Jeanie Bourke - FW: 131 Johnson Rd., BP#2014-02937 plan review comments

From: Jeanie Bourke [mailto:JMB@portlandmaine.gov]
Sent: Thursday, February 12, 2015 4:14 PM
To: dwadetci@gwi.net
Subject: 131 Johnson Rd., BP#2014-02937 plan review comments

Drawings This Sheet:
FIRST FLOOR PLAN

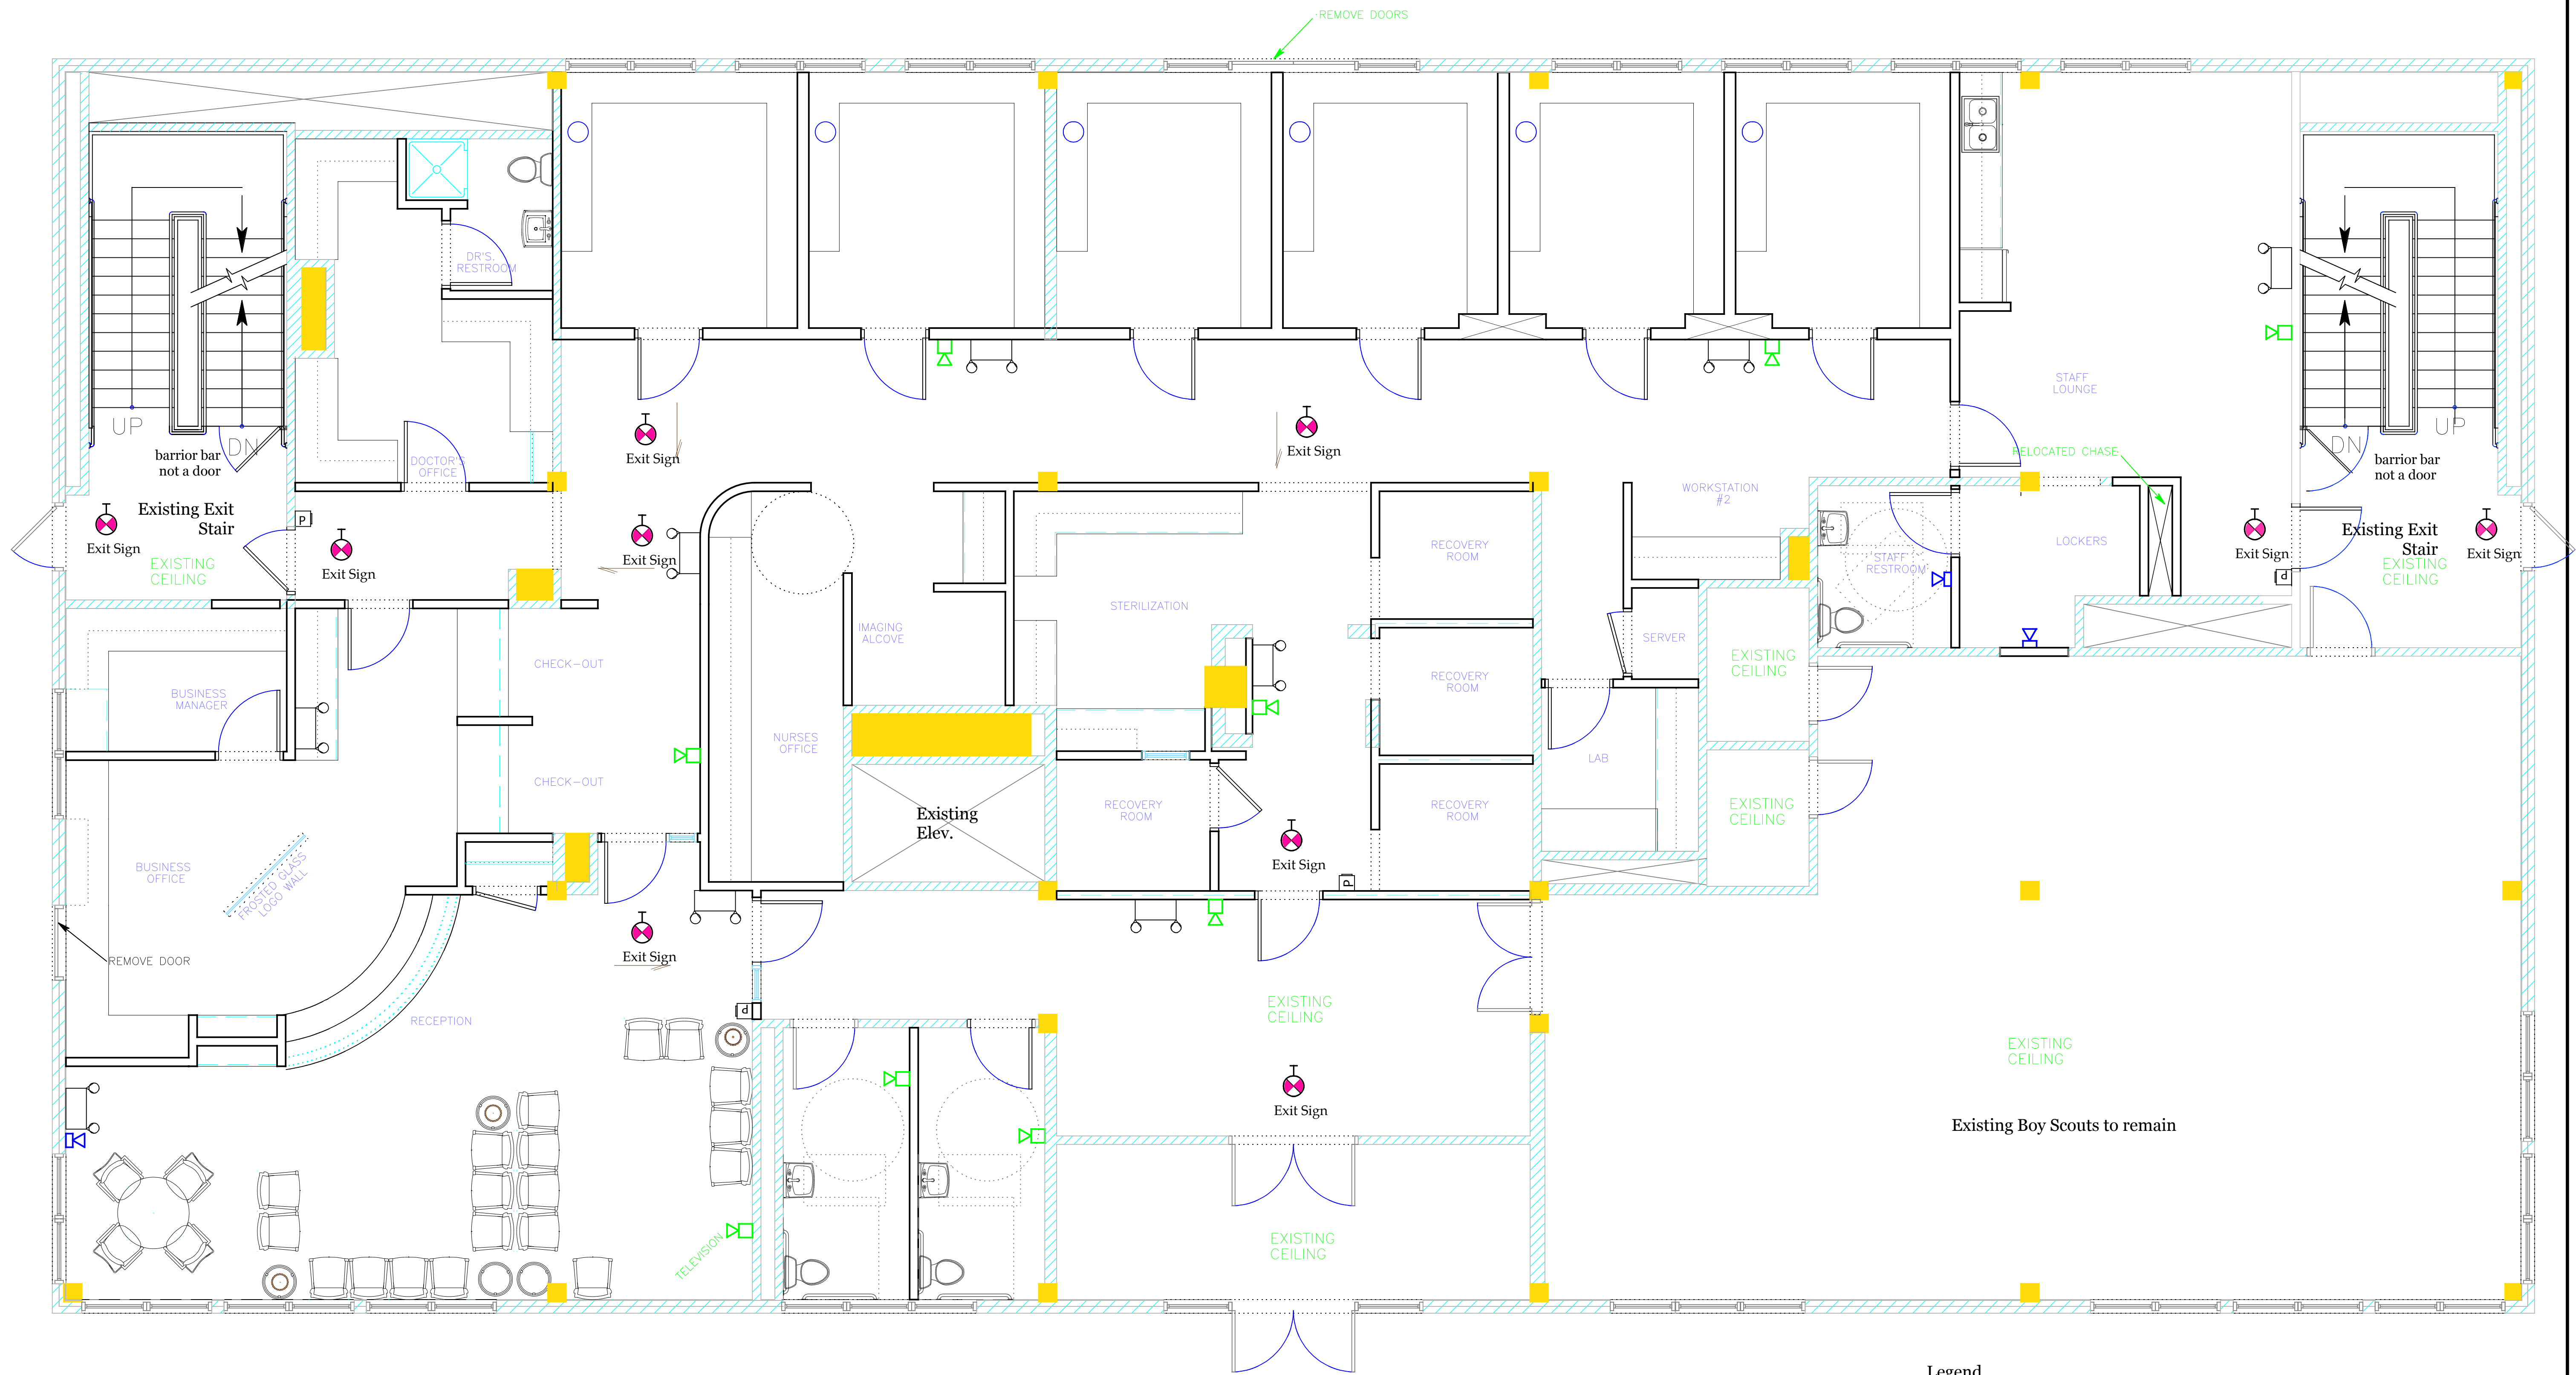
1. Provide a IBC code analysis including use & occupancy, construction type, means of egress, occupant loads, interior finishes etc.
2. Provide a UPC code summary for plumbing fixture count requirements
2. Provide demolition plans.
3. Provide a statement of special inspections for the new structural elements.

- The work is being done in accordance with IEBC, Business / Mercantile use.
- The use has not changed Business / Mercantile.
- Construction type is 5B. The building is sprinkled
- Means of egress per A1 and A2 plus reduce occupancy load
- Original occupancy load was 75+ for the business area. Proposed will be 40+/- . Mercantile has not changed
- Interior finishes will be Class "B" minimum everywhere
- Fixture count is 5 toilets, 1 urinal and 6 sink, not counting the two basement bathrooms. Proposed count is 10 toilets and 10 sinks. The increase is for patient and employee comfort. Again the occupancy load will be less.
- Demolition plans sent
- Let me know what you are looking for in the statement of special inspections
